Application by RWE Renewables UK Solar and Storage Limited for Peartree Hill Solar Farm (EN010157)

The Examining Authority's (ExA's) written questions and requests for information (ExQ1)

Issued on 29 July 2025

SHEET 13 OF 17

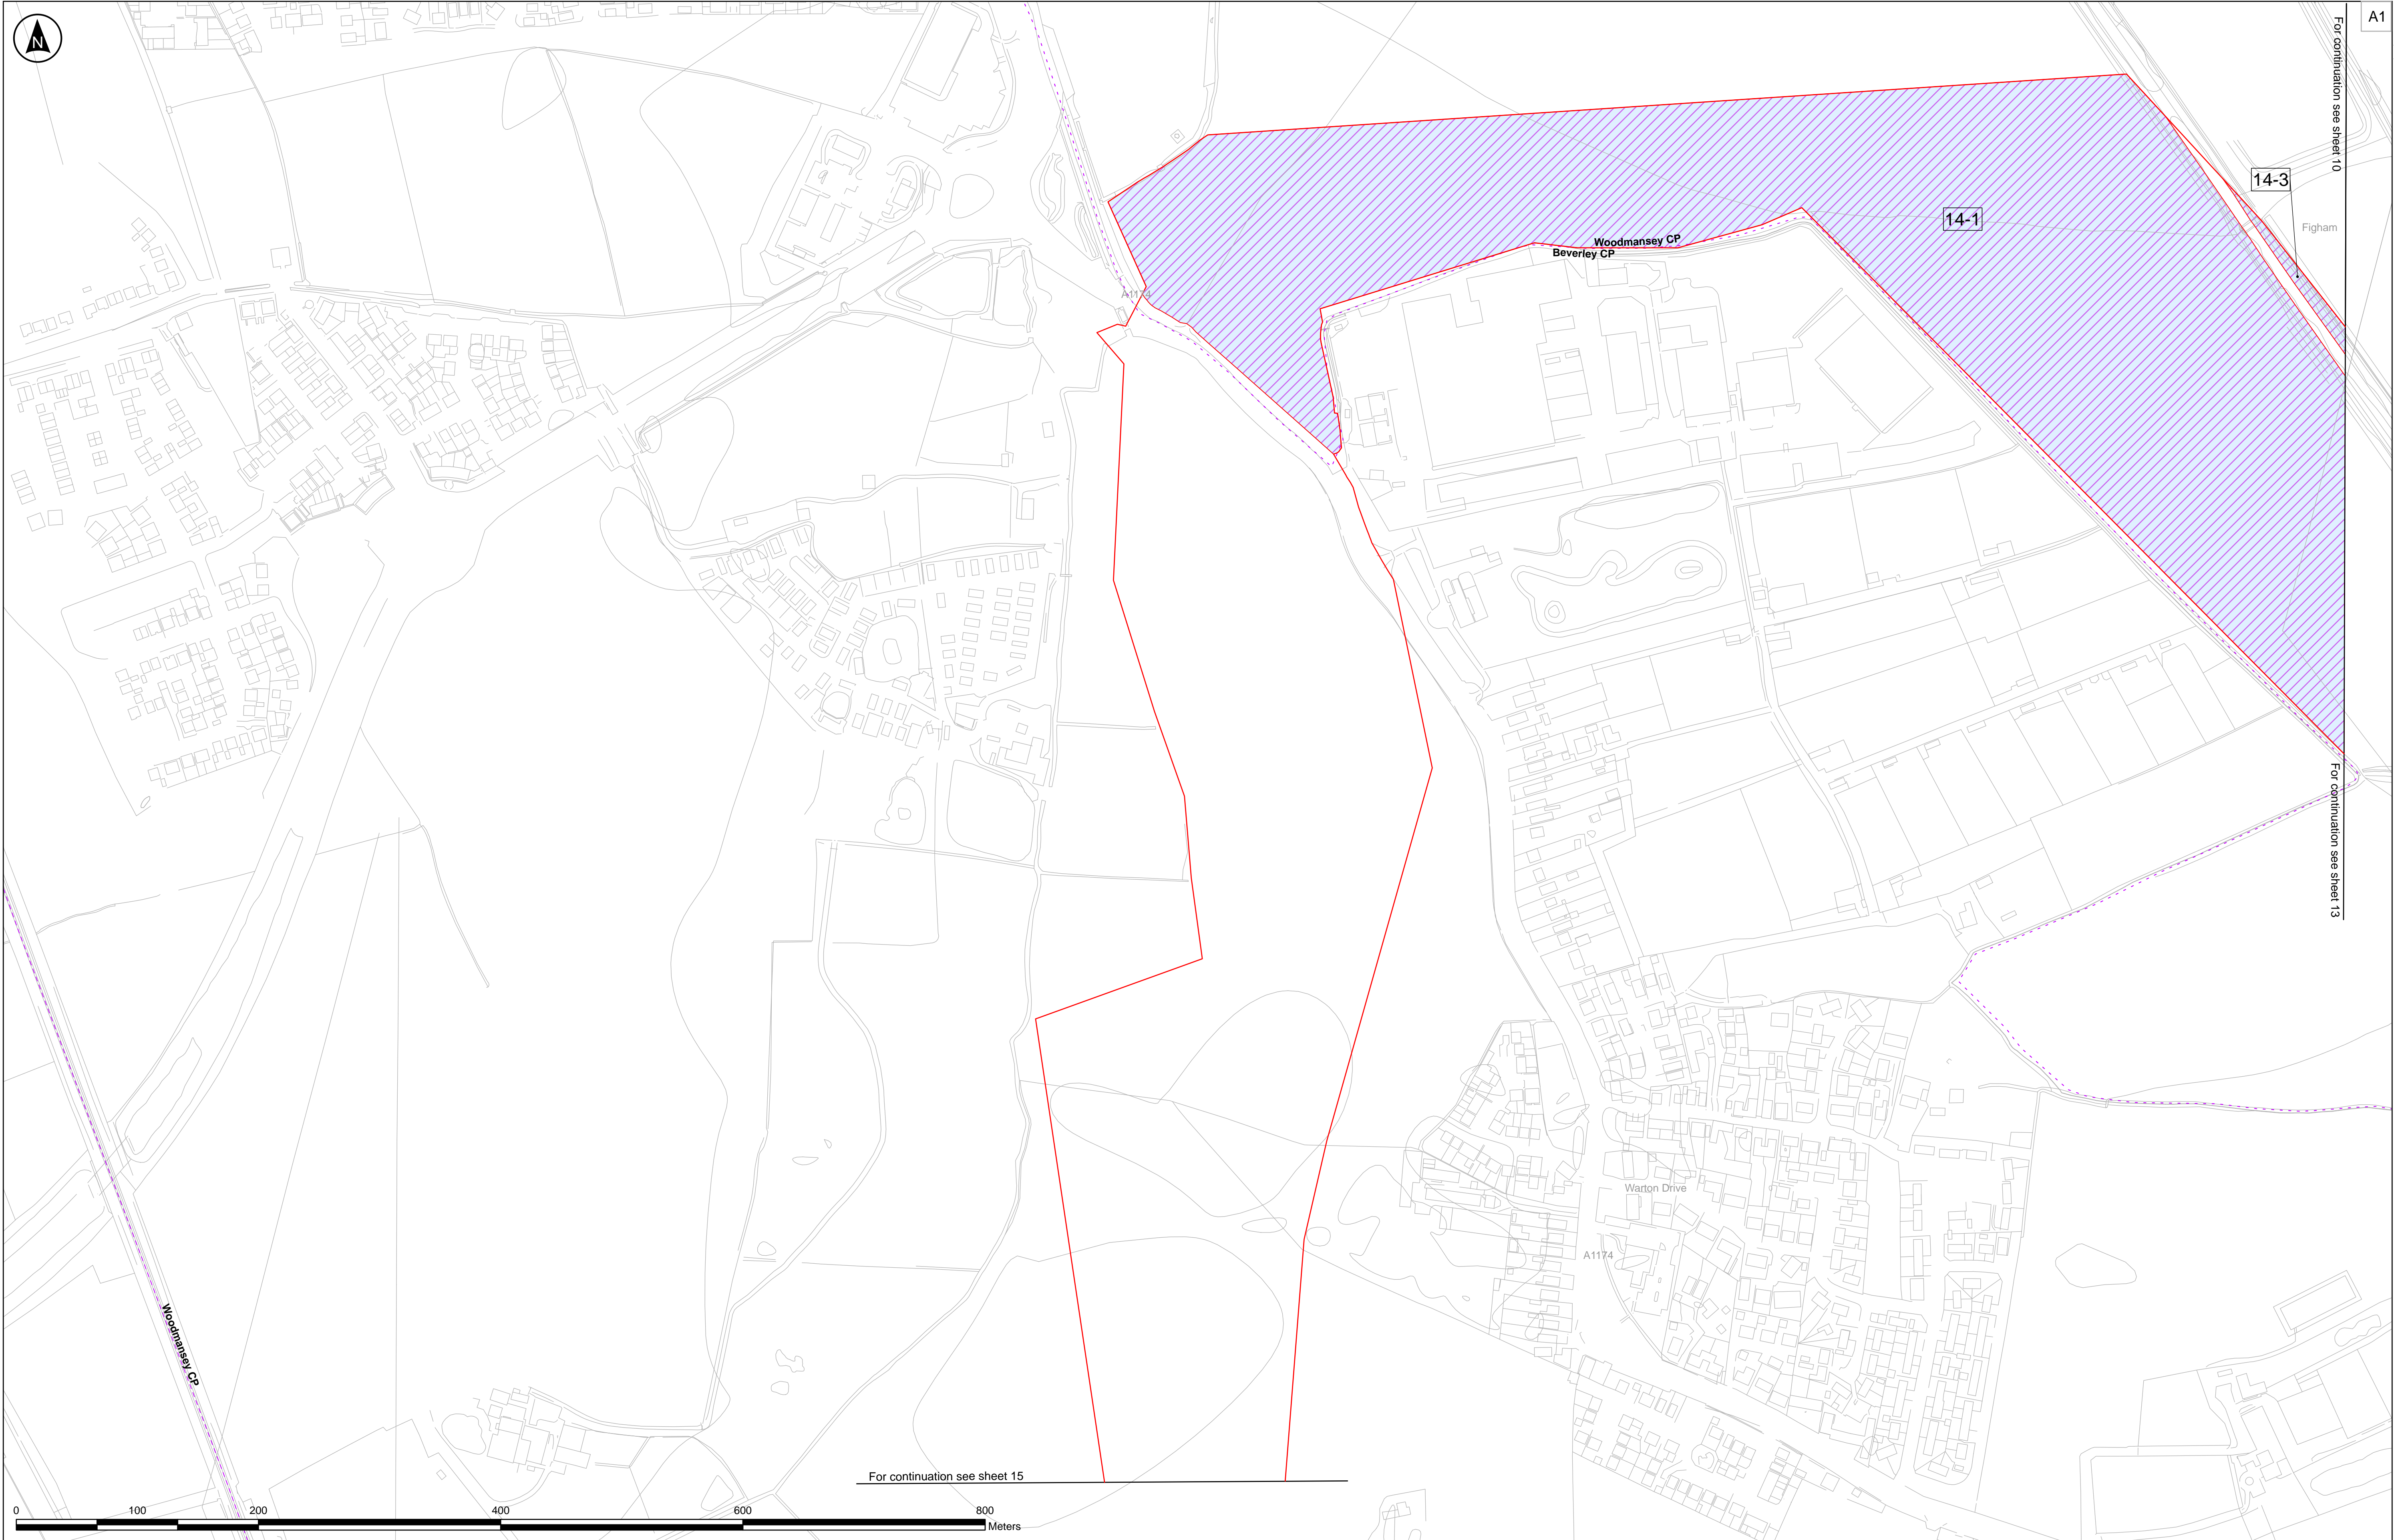
1.2.67	The applicant	Sch 5, Part 2, Tickton Footpath No. 12 – add a space between the words 'sheet 13' and 'of the' in column 2.
